TECHNICAL NOTE

File Ref: MA/PZ/P20-2187/05TN

Subject: Bacon Family – Deadline 3 Response

MAIN DEVELOPMENT SITE
HIGHWAYS WORKS
PROPOSED GENERAL ARRANGEMENT
SHEET 1 OF 9

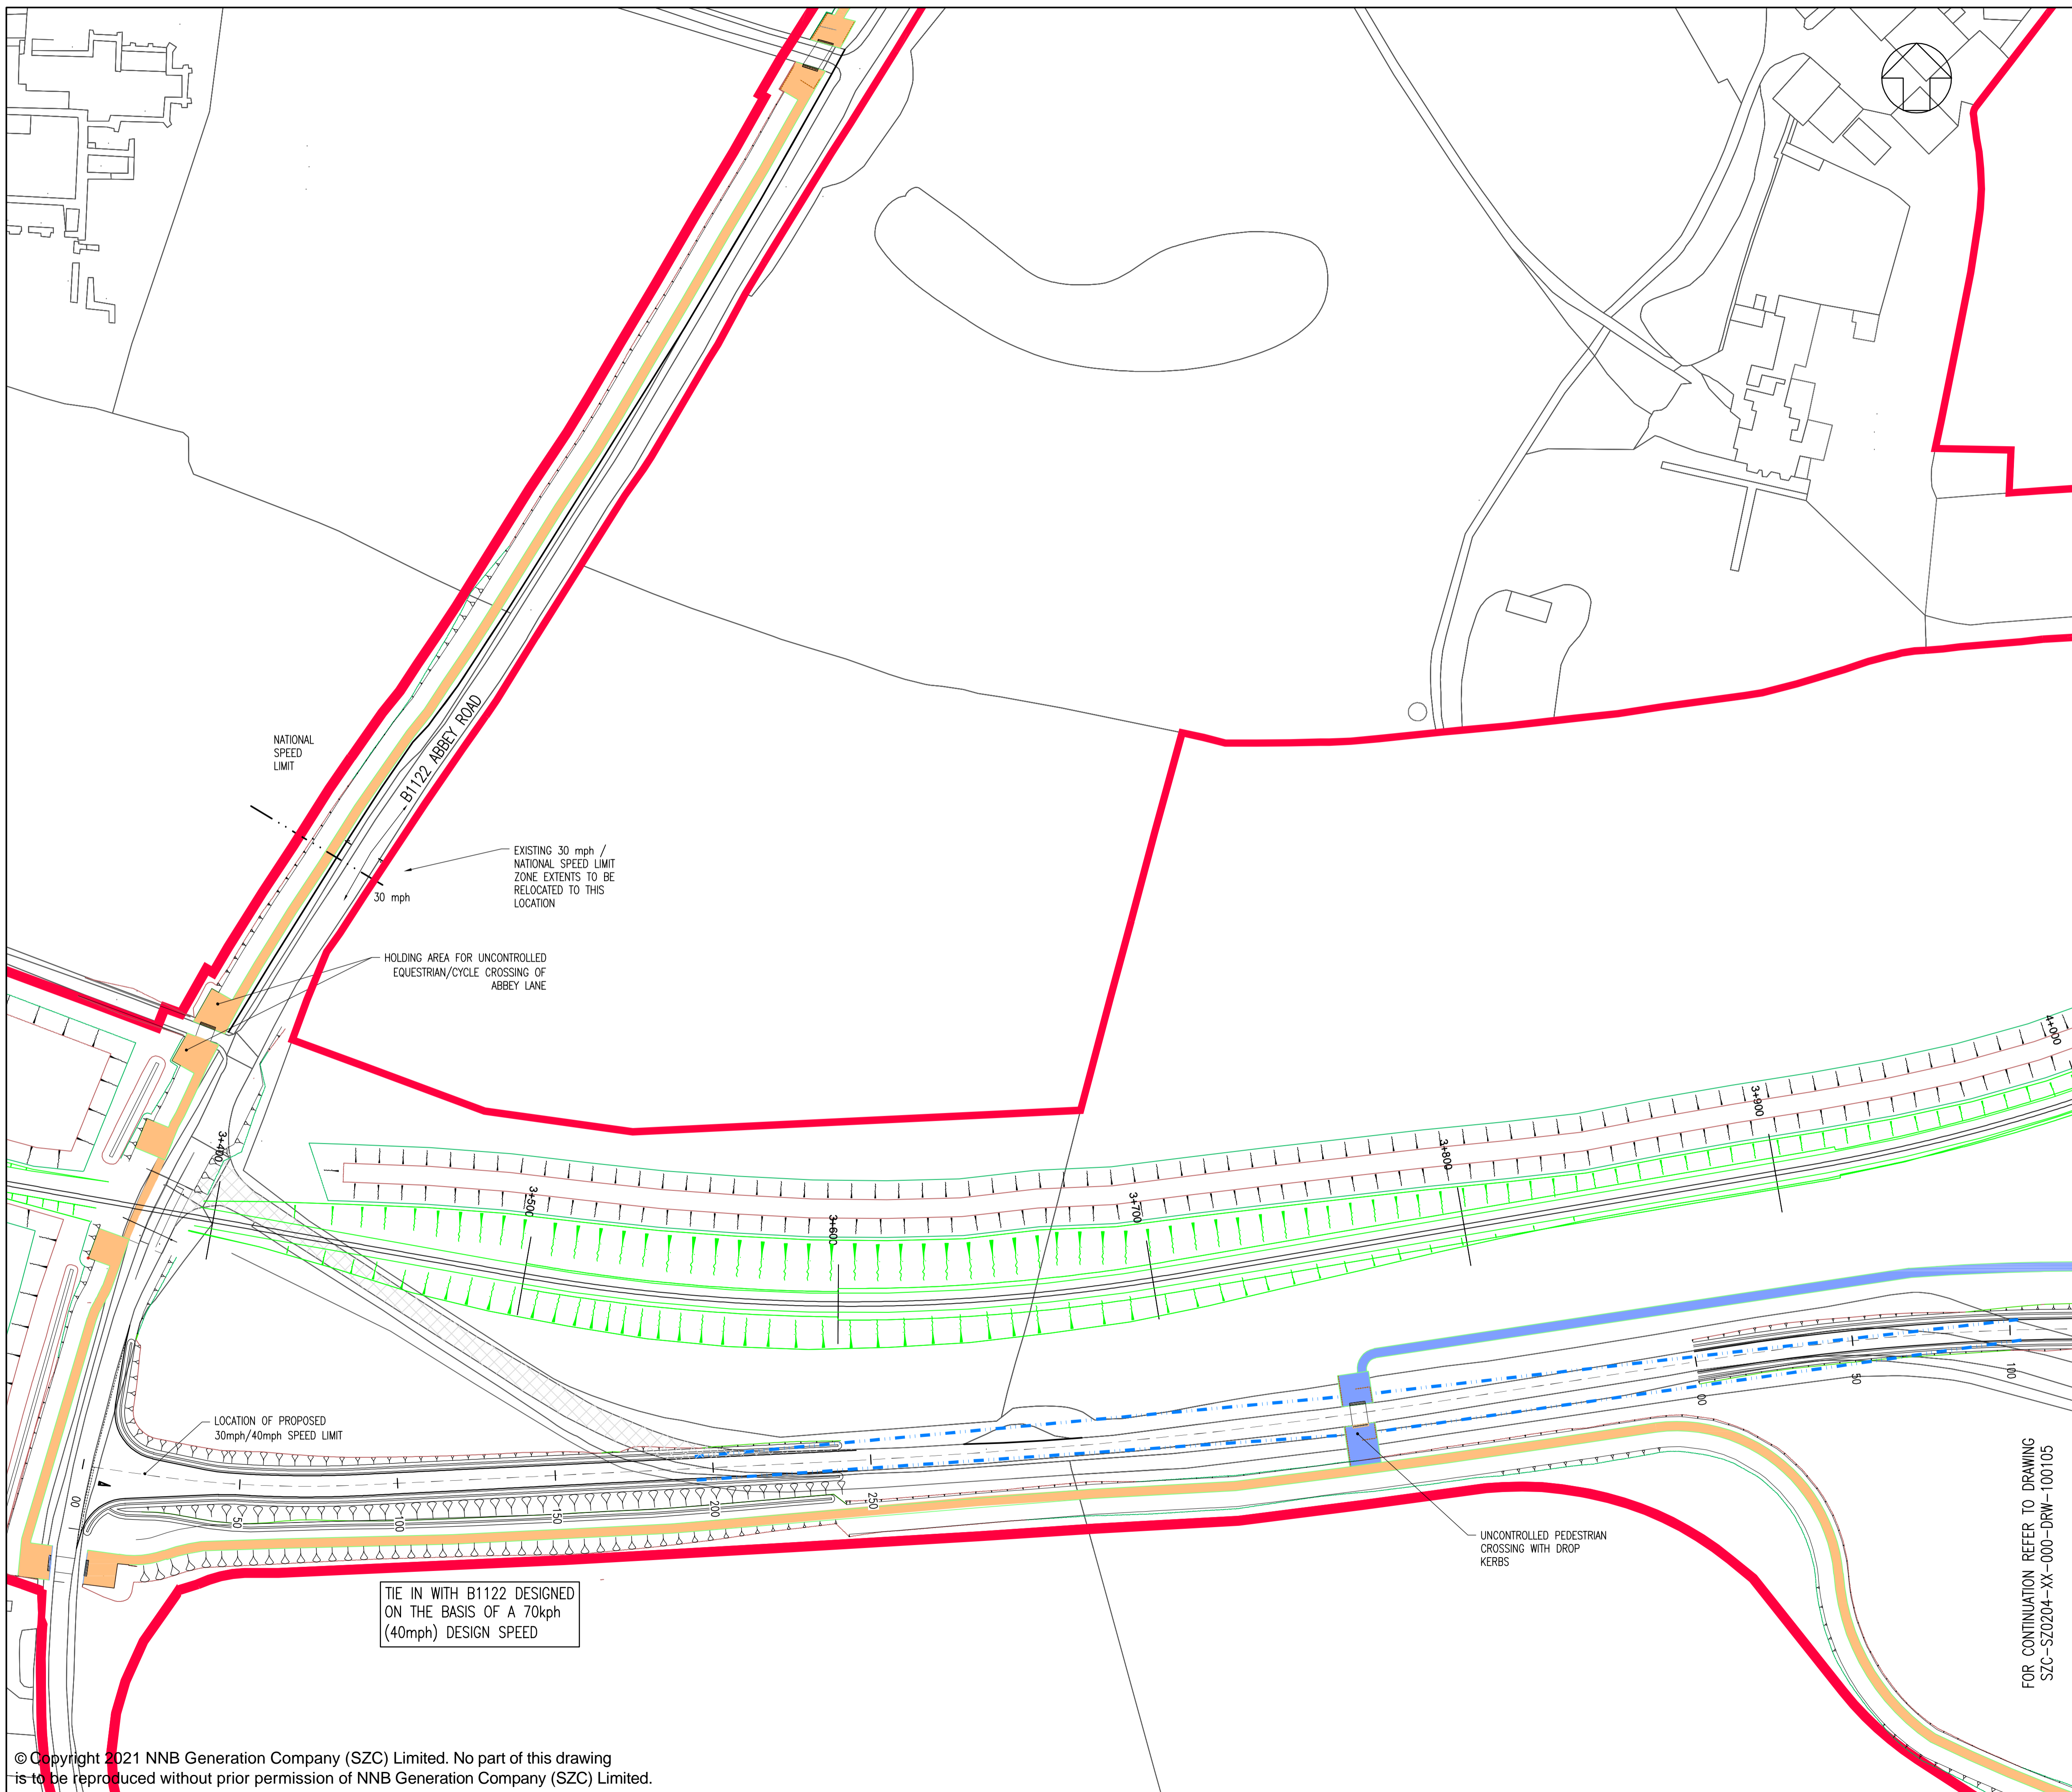
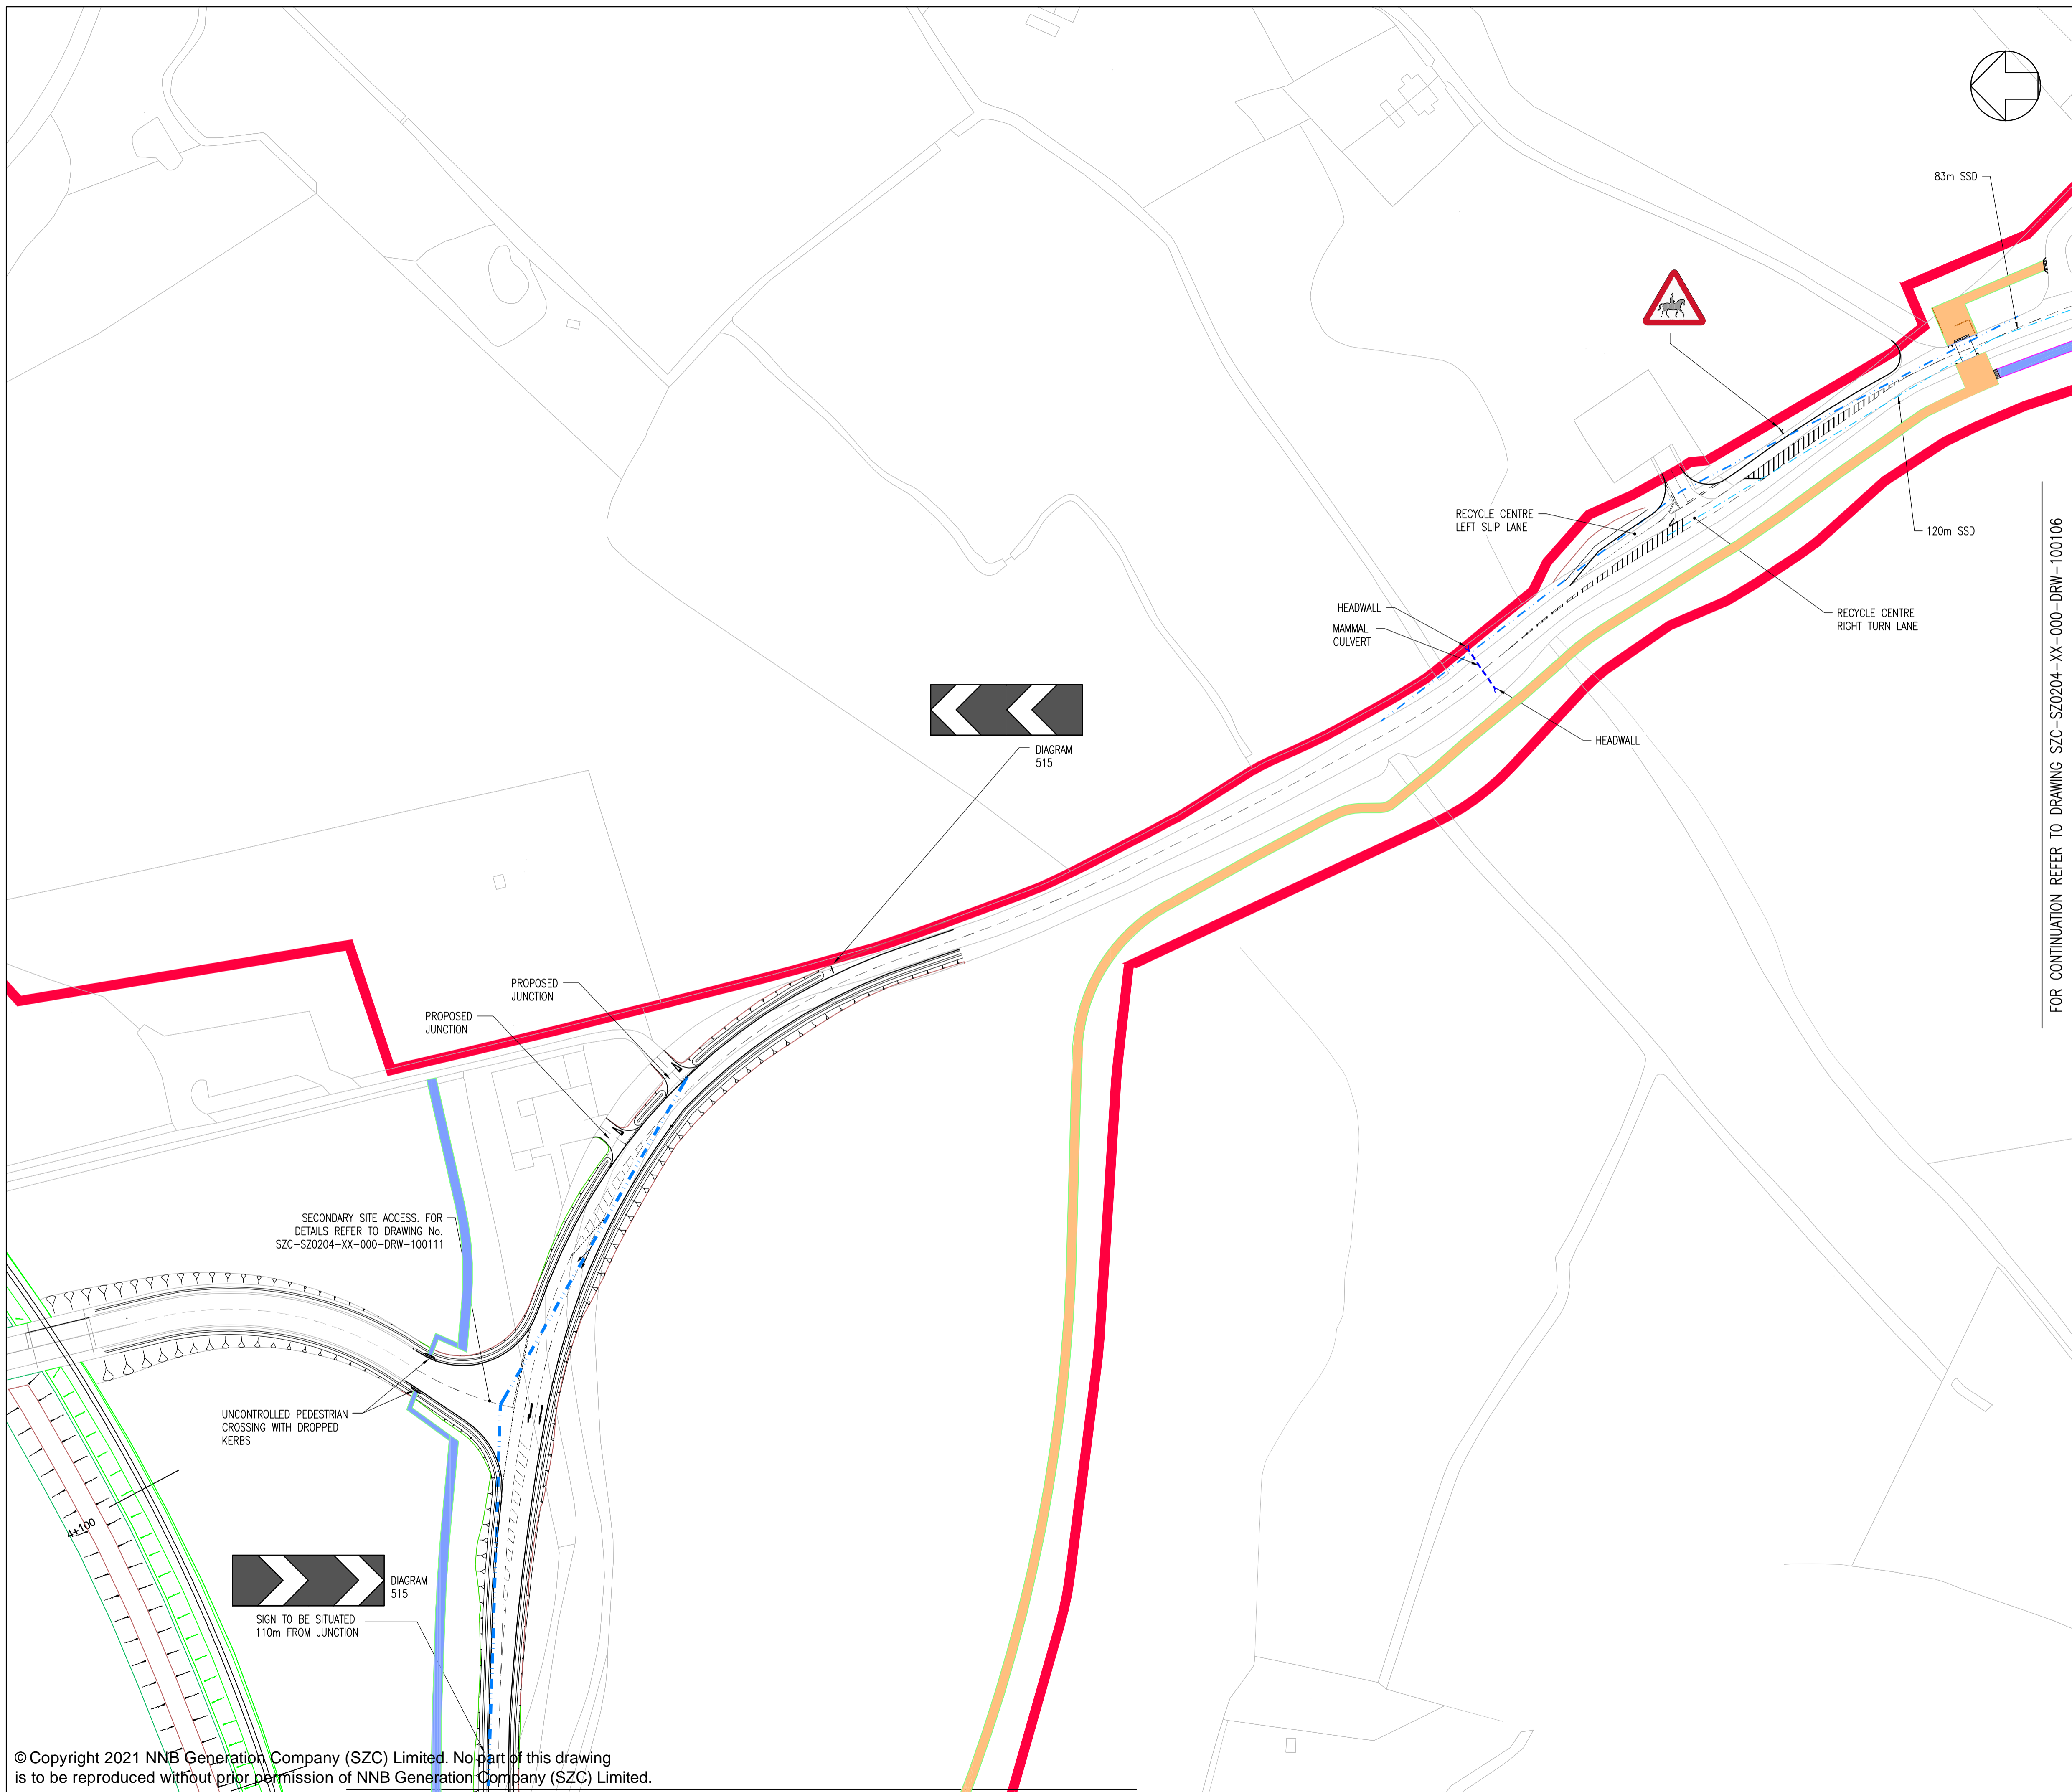
- 3.4 The confirmation in these latest submissions from the Applicant that no construction traffic is to use the B1125 is welcomed. However, Create feel this now reinforces the argument that in

the vicinity of our Client's land the B1122/B1125 junction (as currently proposed by the Applicant) should not give priority to the B1125.

- 3.5 To further discourage use of the B1125 we suggest there is also an argument that the B1125 should not link with the SLR at all and should terminate at the B1122 (as is currently the case).
- 3.6 Traffic heading southwards along the B1125 could then join the B1122 which in turn would lead to the SLR at the junction arrangement which is proposed to the West. This would result in a less direct link between the A12 and SLR (via the B1125) and make the route less attractive than the current scheme, and could potentially minimise the land-take if the B1122 were to follow its existing alignment.

- 3.7 As a minimum, the future B1122/B1125 junction layout should give priority to the B1122 (as is currently the case) with comprehensive traffic management measures implemented from the A12 (at Blythburgh) along the B1125 to the B1122 in the South.
- 3.8 Measures for the B1125 alongside the Applicant's own enforcement measures could include:
- 20mph village zones;
 - Village gateway features;
 - Village gateway signing i.e. "Please drive carefully in the village";
 - Flashing Speed Limit Signs together with regular enforcement;
 - Sections of carriageway narrowing/shuttle-working;

- 4.5 Create requests the Applicant revisits the B1125/B1122 strategy particularly in terms of the proposed B1122/B1125 junction format, the potential disbenefits of a direct connection between the B1125 and SLR and general measures along the B1125 to offer a permanent legacy benefit to the local area.
